# CITY OF ALBUQUERQUE

**RE: Wilderness Canon  
Engineer's Certification  
Grading and Drainage Plan Date: 2/18/16  
Engineer's Certification Date: 6/28/17  
Hydrology File: F23D012**

Re: Final Grading and Drainage Certification Wilderness Cañon at High Desert - DRB Case  
No. 1004989

GRADING PLAN

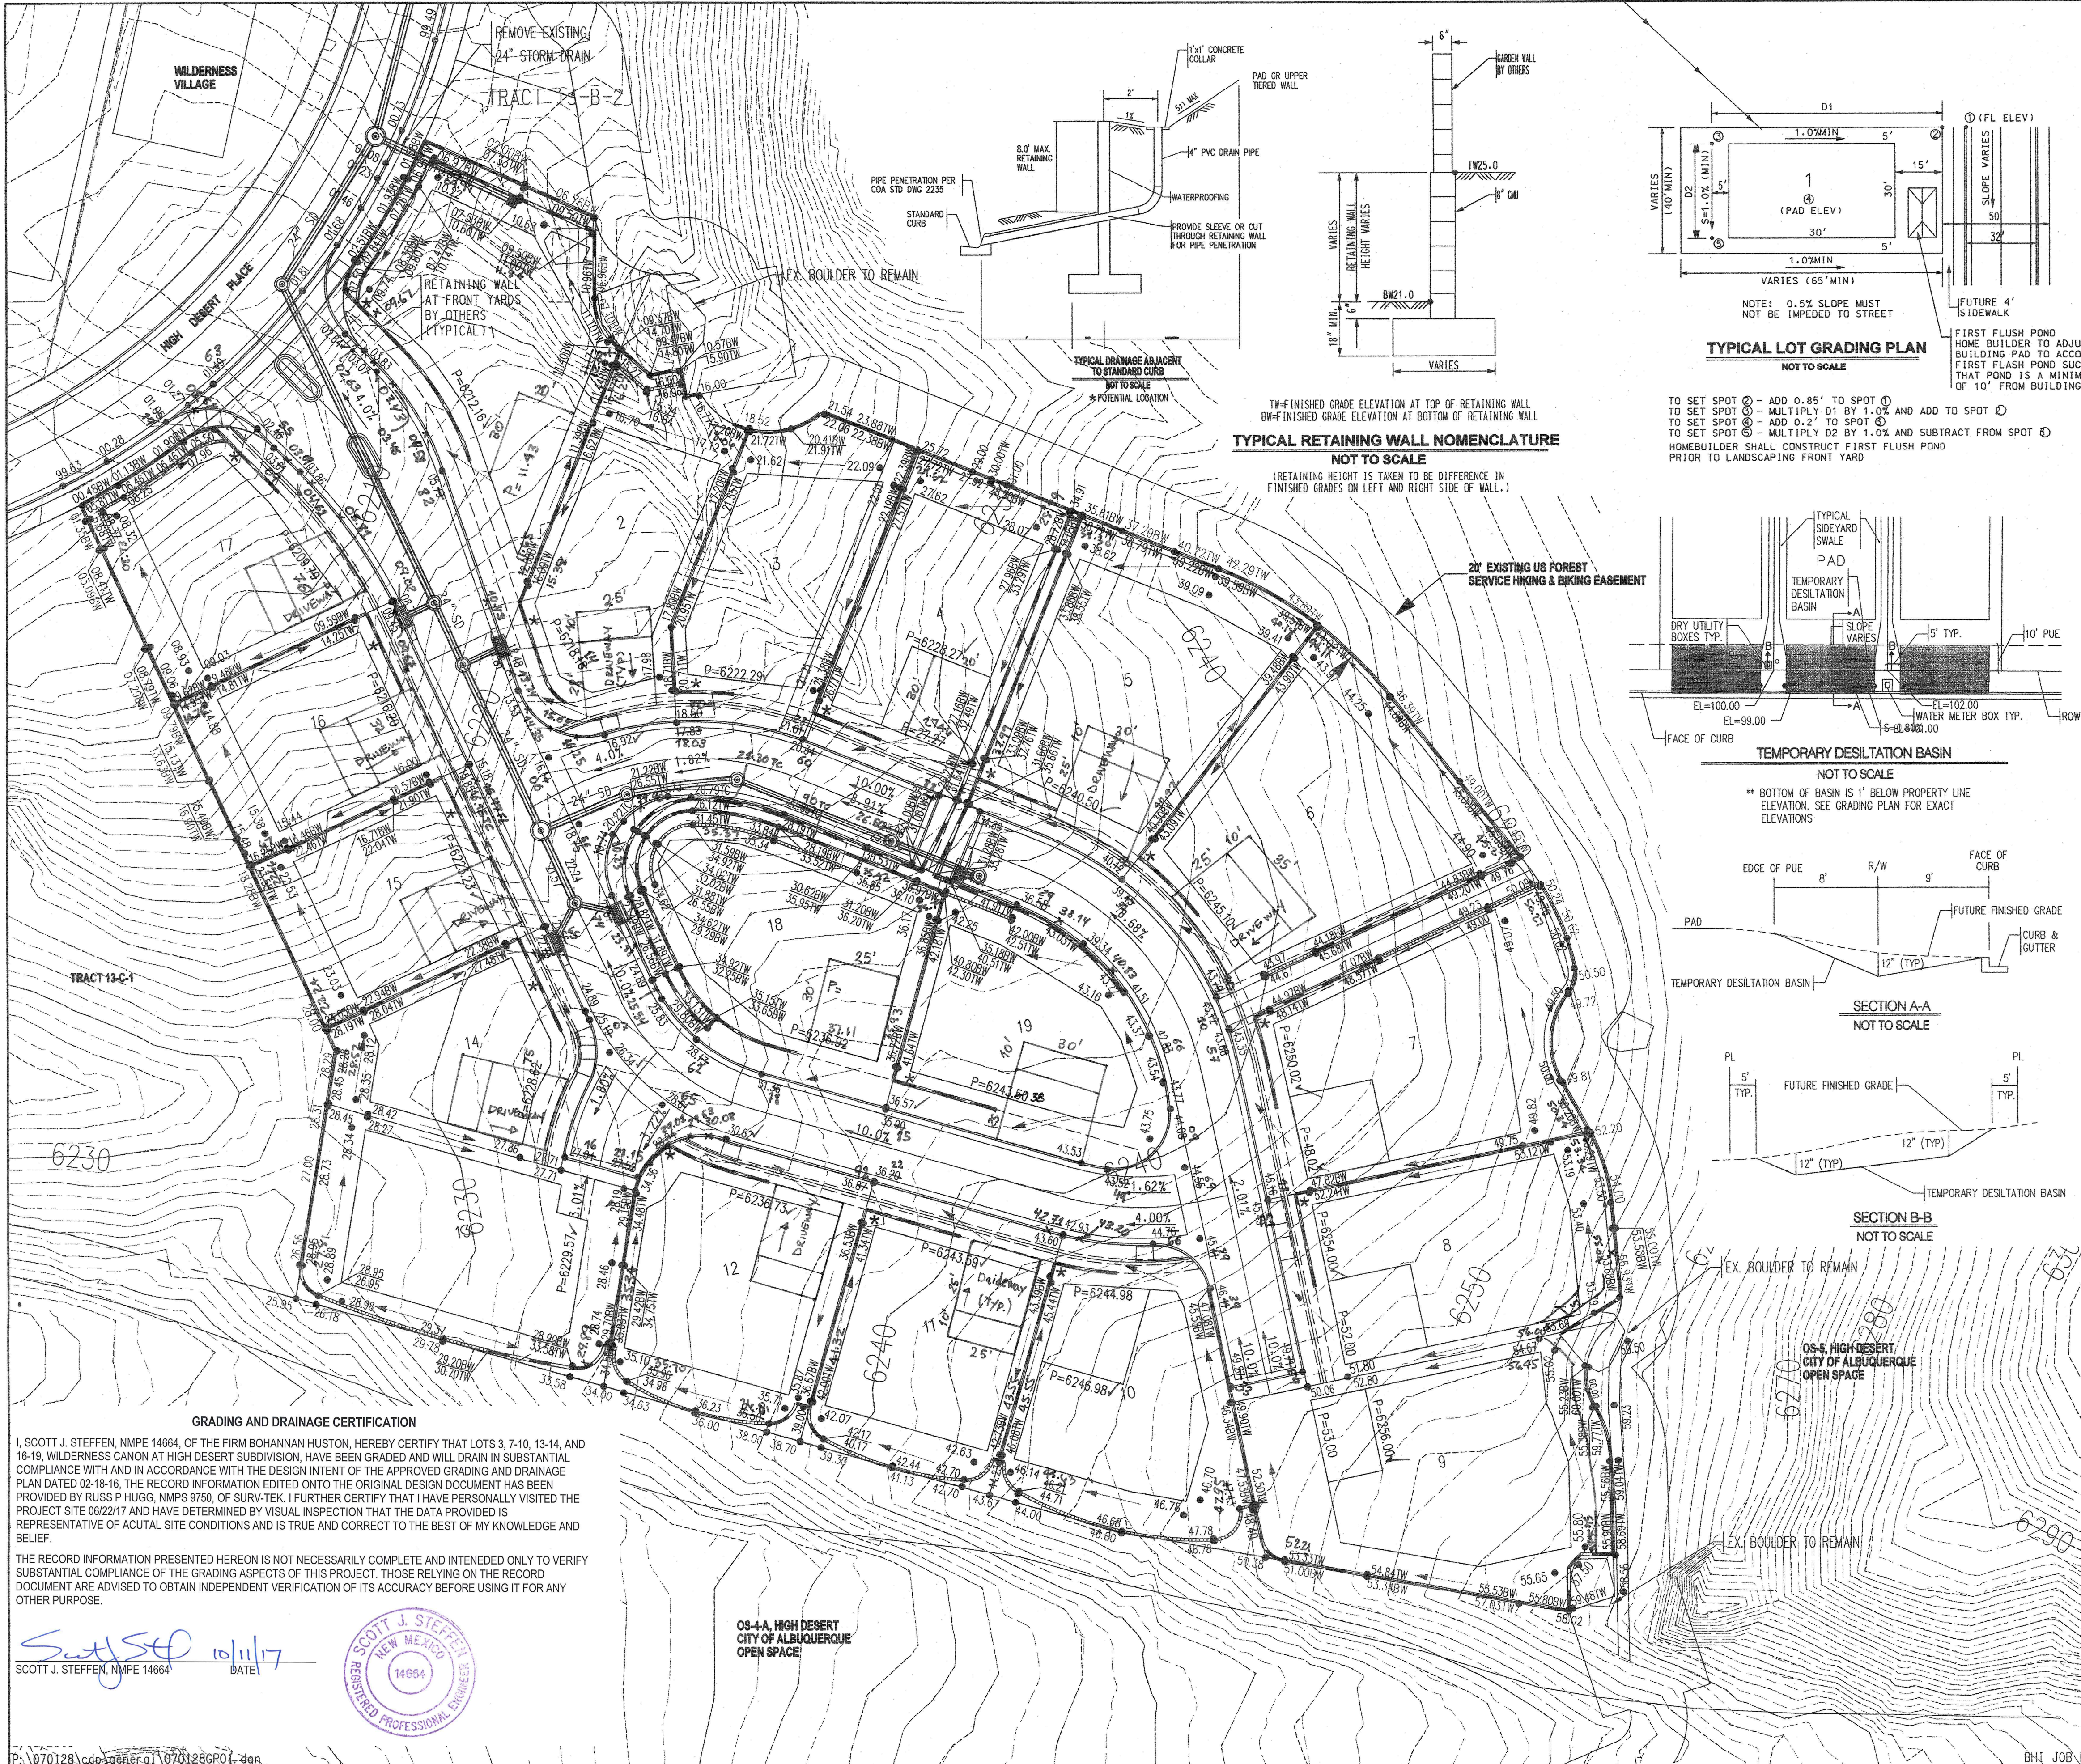
1. All site grading and drainage must be certified, including infrastructure, per Ch. 22 (7) of the DPM. Please resubmit with the sheets showing the swale and pond.

2. Sufficient survey is required along the channel alignments in order to validate channel slopes, and dimensions.
3. Disturbed slopes around the pond and swales in the Open Space need to be stabilized (reseeded).

4. Several areas of concern along the channels were noted during the final inspection as deviating from the plans:
  - Drainage channel behind lot 7. The channel flattens out here and may not perform as designed.

- Drainage channel at the private access easement (between lots 7&8). Channel width and depth contract here, if drainage jumps the channel it will likely end up running down the access road and into the subdivision.

- Drainage channel behind lot 5. At end of the upper channel, the 5'x5' pad is not built and the channel does not transition to divert flows across the trail to the natural arroyo. Instead the channel ends, creating a pond. In the same area, there is a low spot on the outside of the curve (curve 9, from the 2/22/16 trail/swale plan). It is likely that high flows will back up and jump the channel, then run down along the retaining walls behind lots 5-2.

- Swale to pond channel, adjacent to High Desert Place. Bottom width is less than design, in several spot along the lower half. However, the channel also appears to be deeper than designed.

Hydraulic capacity in these areas needs to be rechecked to reflect as-built conditions, or the channel needs to be rebuilt per design.
